**SUBJECT: BRES2301-0066**  
**BUILDING RESIDENTIAL**

Here are the results of all Inspections located at **255 STONEY CREEK DR:**

FLOOR 2x8
16" joist
2x8
BAND

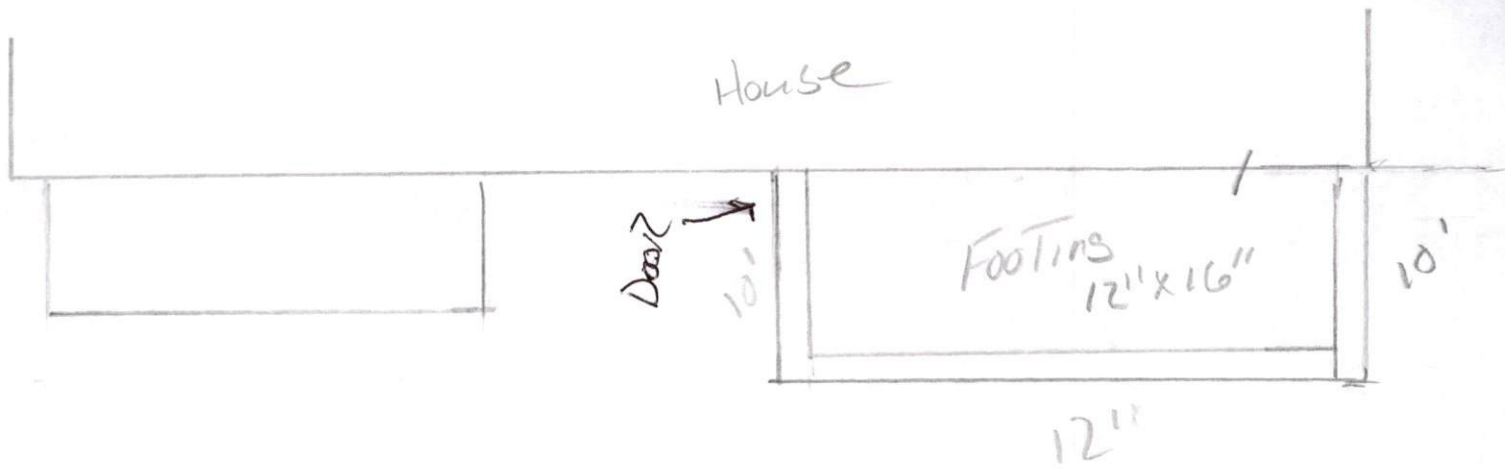
Inspection Type: FOOTING  
Scheduled Date/Time: 2/22/2023  
Completed Date/Time: 2/22/2023  
Inspector: Steven Gazlay  
Result: DISAPPROVED  
Remarks:  
Notes: Dowel to existing other. 2 pieces number 4 bar each side.

Inspection Type: ROUGH IN  
Scheduled Date/Time: 4/5/2023  
Completed Date/Time: 4/5/2023  
Inspector: Steven Gazlay  
Result: DISAPPROVED  
Remarks:  
Notes: Remove insulation to allow for visual inspection, Missing insulation baffles Ridge beam must be longer than cut face of rafter. need collar ties. Seal plumbing penetration to floor. Add cripple studs adjacent doorway. Need tempered window at bathtub. Need correct number of kings and jack studs on opening. Nail ceiling joist to rafters. Block frame fly rafters . Flash penetration for bath fan. Cannot tape over bottom of window flange.
